Planning Application No: 3/2024/0625

Proposal: Proposed demolition of existing conservatory, garage, oil store and the north west corner of the building. Construction of canopy over front door, single-storey extension to side and single-storey extension to rear with decking. Construction of double garage with mezzanine storage above including new paved area and resin bound hardstanding to front. Installation of electric gates at vehicular entrance.

Location: High Lea Cottage Whins Lane Simonstone BB12 7QU

The submitted documents and plans have been reviewed and the following comments are made.

PL06: Drawing of the proposed Garage front elevation

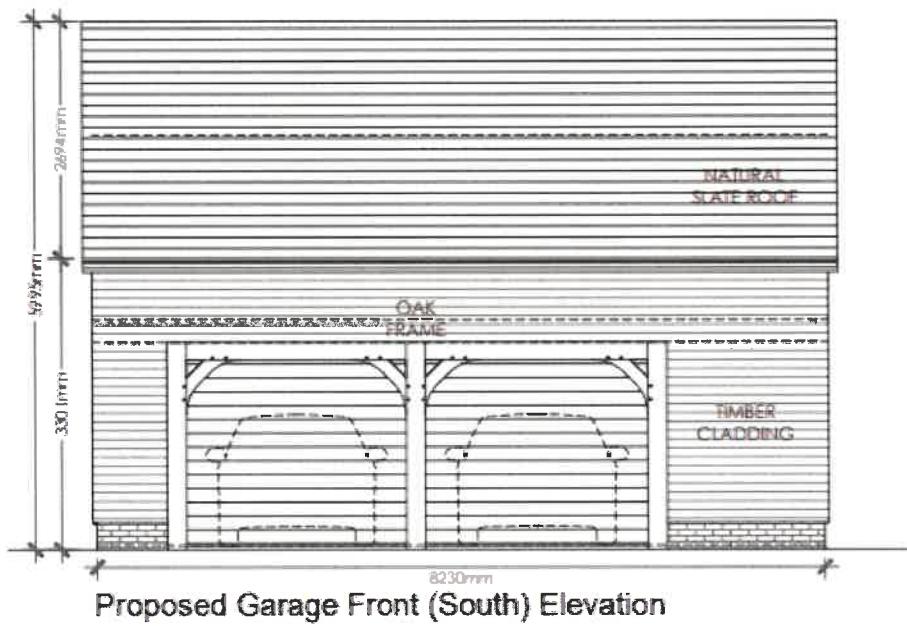
The proposal increases the number of bedrooms from an existing 2 to a proposed 4. Parking standards requires 3 off street parking spaces for this size of proposal. Ref. Design and Access Statement 4.0 Proposed Garage (PL06), these can be provided within the curtilage.
